SSD 7317 MODIFICATION 3 – RESPONSE TO SUBMISSIONS

This Response to Submissions report (RTS) is submitted to the (the Department) in support of Modification 3 to amend State Significant Development (SSD) consent SSD – 7317 relating to the construction of a commercial campus at the Australian Technology Park, Eveleigh.

1 DA PLAN - BELOW GROUND
1 : 125

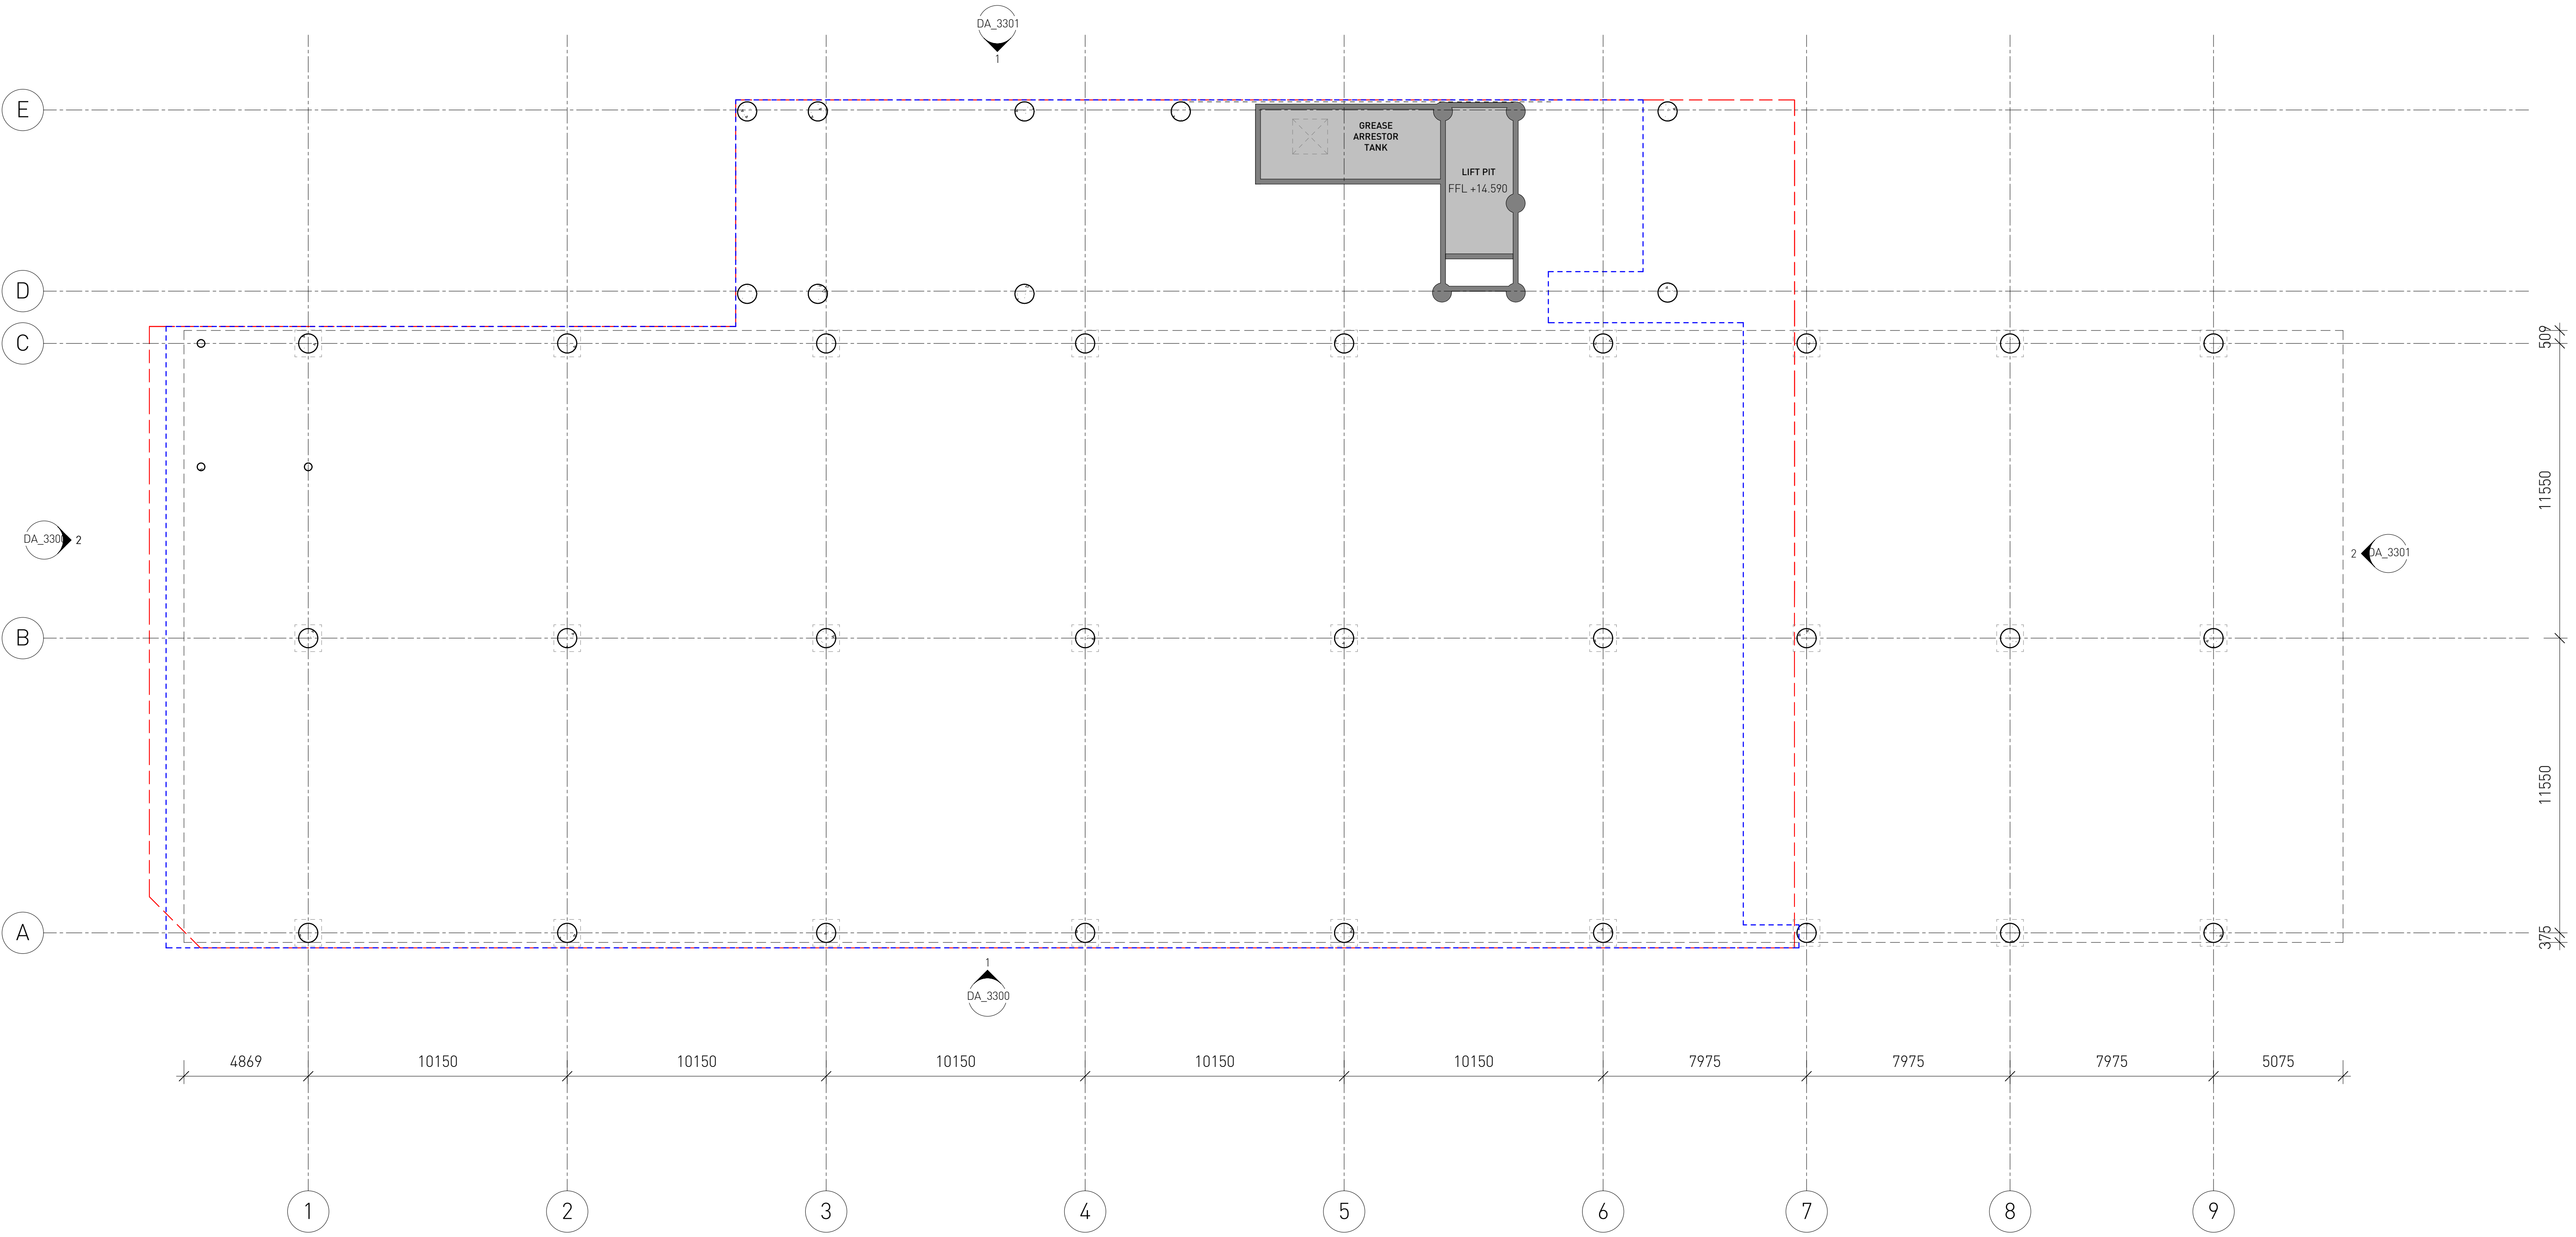
It is noted that the proposal seeks to relocate services including the rainwater tank from the Below Ground Level. Opportunities to provide surveillance to the Oval and a landscaped outlook for the facilities over the green would be better managed by retaining services on the below ground level where possible.

The relocation of services from the below ground level has occurred due to the need to minimise excavation and to maximise the efficiency of the building. The relocation to the ground floor provides a consolidated services area more appropriate for management purposes and removes the requirement for access below ground.

On reviewing the efficiency of the building (comparison of the net leasable area, gross floor area and gross building area) the approved design was insufficient in terms of development standards. To improve the efficiency and spatial requirements for services and user usability, back of house and circulation were reviewed and rationalised where possible which included bringing some of the in-ground services to the ground floor and onto the roof.
